Our reference: P-604273-G6X6  
Contact: Sandra Fagan  
Telephone: (02) 4732 7992

19 January 2024

**Council Response to Modification Report - SSD-10448-Mod-6 – Aspect Industrial Estate at 804-882 Mamre Road, Kemps Creek, NSW, 2178.**

Figure 1: Site Plan

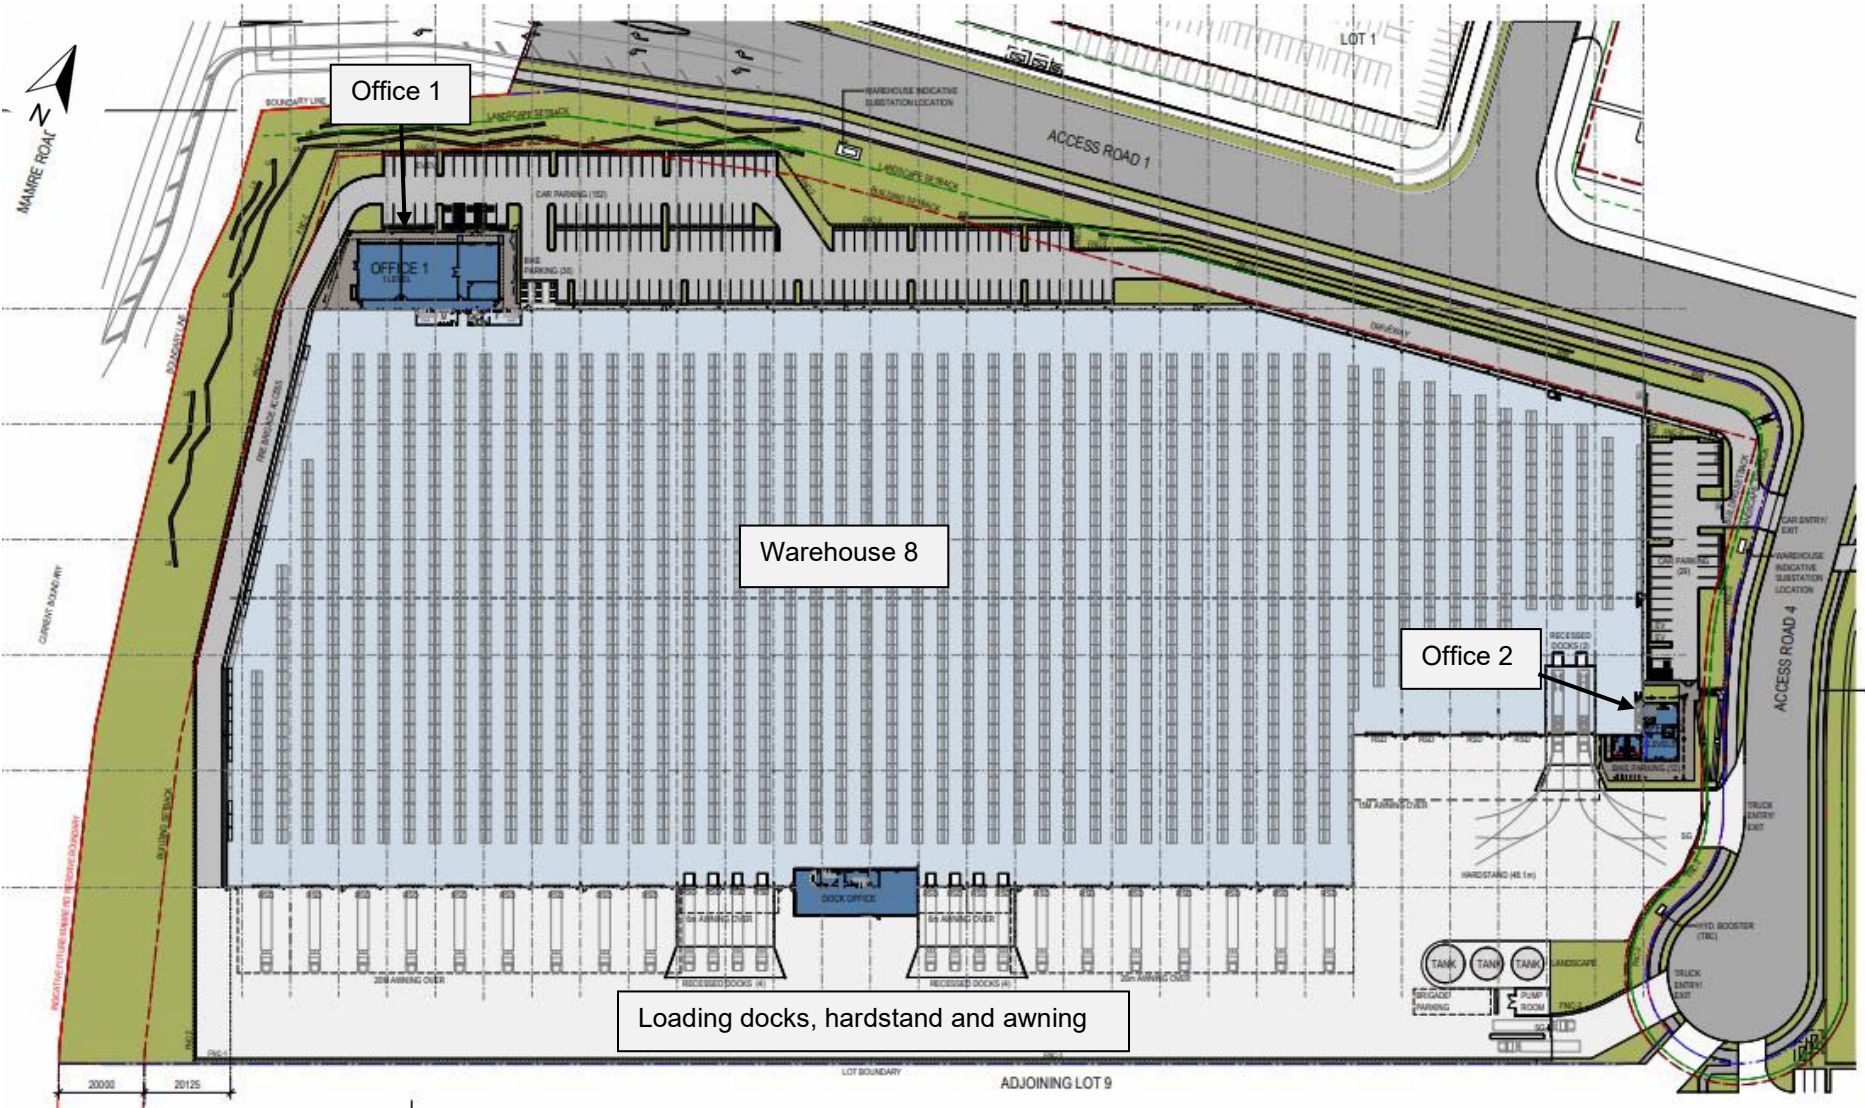
Council's Traffic Engineering Department have reviewed the proposal and note that aligning four driveways close to and at the turning head of Access Road 4 may cause queuing on the road.
